KITTITAS COUNTY FIRE MARSHAL'S OFFICE

February 23, 2011

Re: Anderson (BL-10-00048)

PROPOSED

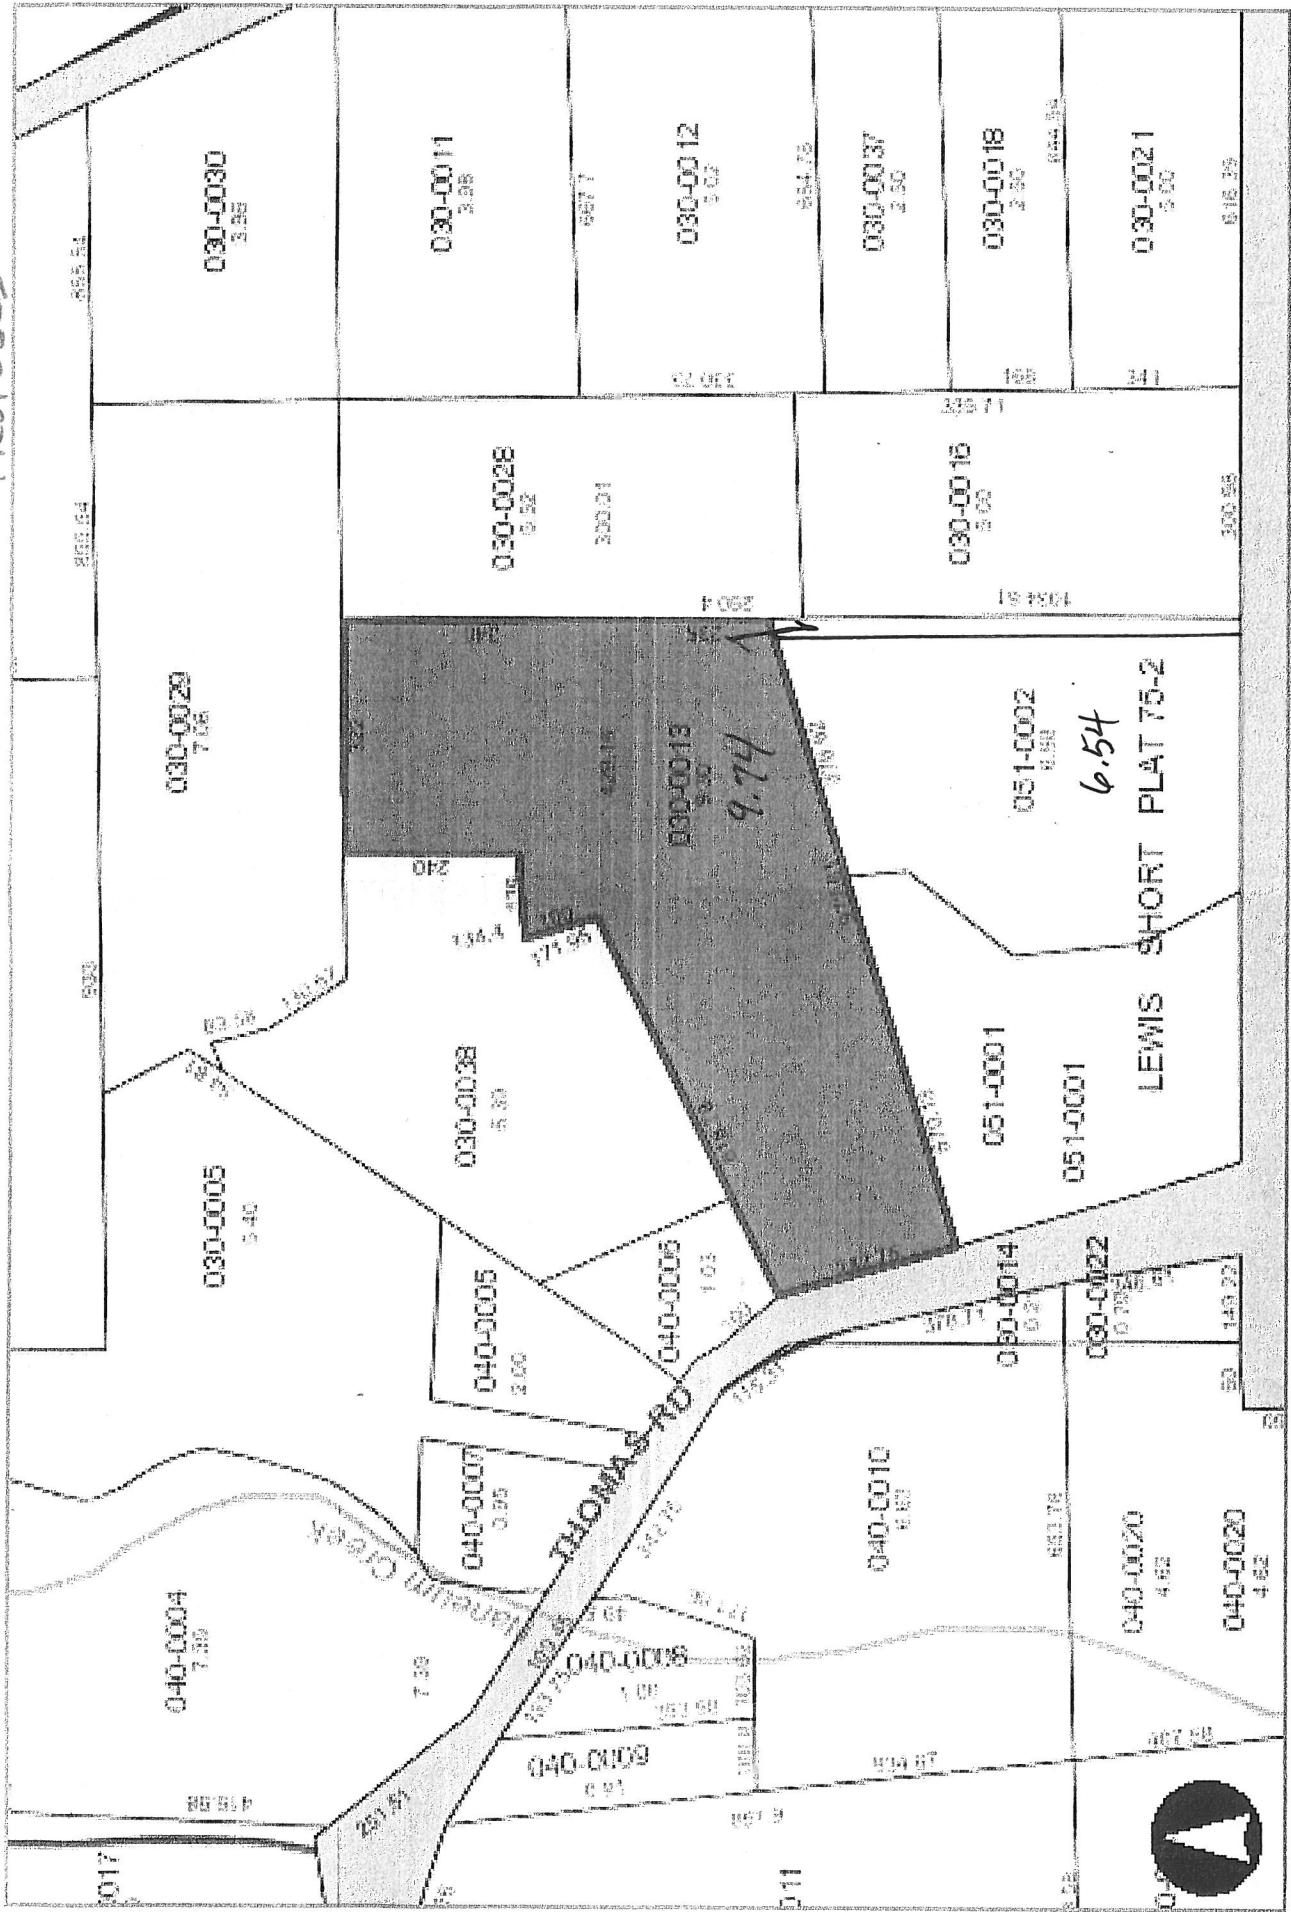
- Ensure that boundary line adjustments do not infringe upon existing structures, to include propane tanks, etc.
- Creation of any additional roads or access must comply with the International Fire Code.
- All future development must comply with the International Fire Code.
